11 August 2025

SSD 83956216
DA184/2025/1
JD6 (P&E)

**STATE SIGNIFICANT DEVELOPMENT APPLICATION 83956216
105-153 MILLER STREET NORTH SYDNEY
NEW UNIVERSITY CAMPUS
APPLICANT: INVESTA CUSTODIAN (2) PTY LTD**

I refer to the Department's request for advice regarding the subject State Significant Development application for 105-153 Miller Street North Sydney, being the adaptive reuse of the former MLC Centre for the purpose of a new university campus. Following a review of available documents, herein Council provides advice and recommended conditions of consent are attached, as requested.

Proposed - Elevation (view from Miller Street)

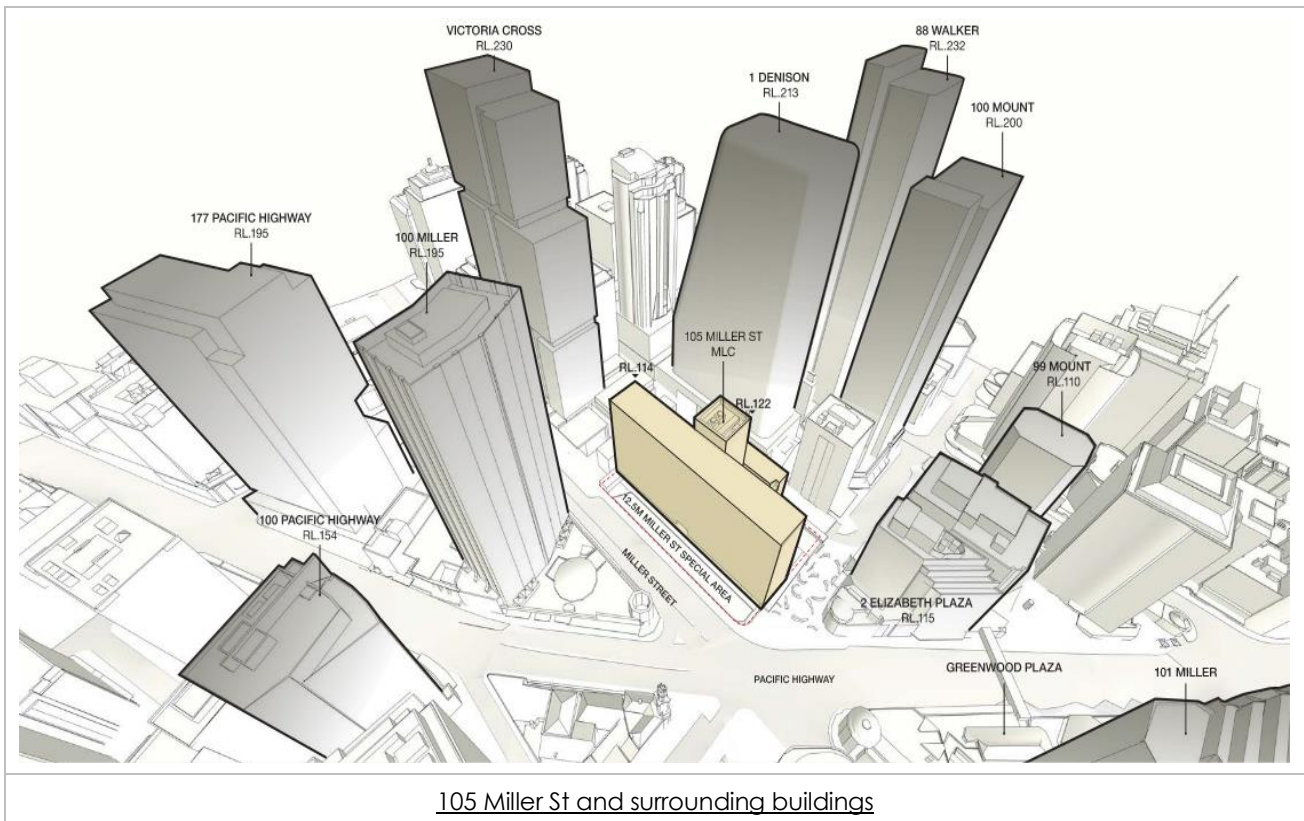
Compared to the commercial proposal, the university campus proposal's ground floor maintains the primary entry from Miller Street and proposes the entire level be used as an "Entry Lobby" except for the Auditorium. Nothing on the plans indicates how this space creates interactivity between this internal space and the adjacent public domain.

Without any further detail than that offered by the plans, the design report and the environmental impact statement, it is difficult to ascertain how the vaguely defined activities in the "University Hub" and "Entry Lobby" spaces will activate the public domain adjacent to the building, including key spaces such as the colonnade to Miller Street, the stairway from BWP to the plaza above, the southern entry to the building, and the terrace in the north eastern corner of the podium, outside the auditorium.

In the absence of details to describe and illustrate how the “Hub” and “Lobby” could contribute to public domain activation on three frontages and the expanse of terrace outside the auditorium, these elements should be detailed to demonstrate significant benefit to street life in the North Sydney Centre.

Revised plans and documentation providing a detailed description of each level of the “University Hub” and adjacent outdoor areas, demonstrating how they will suitably activate the public domain, commensurate with the activation likely to be achieved by the proposed commercial redevelopment currently being assessed by Council (DA 387/24/1).
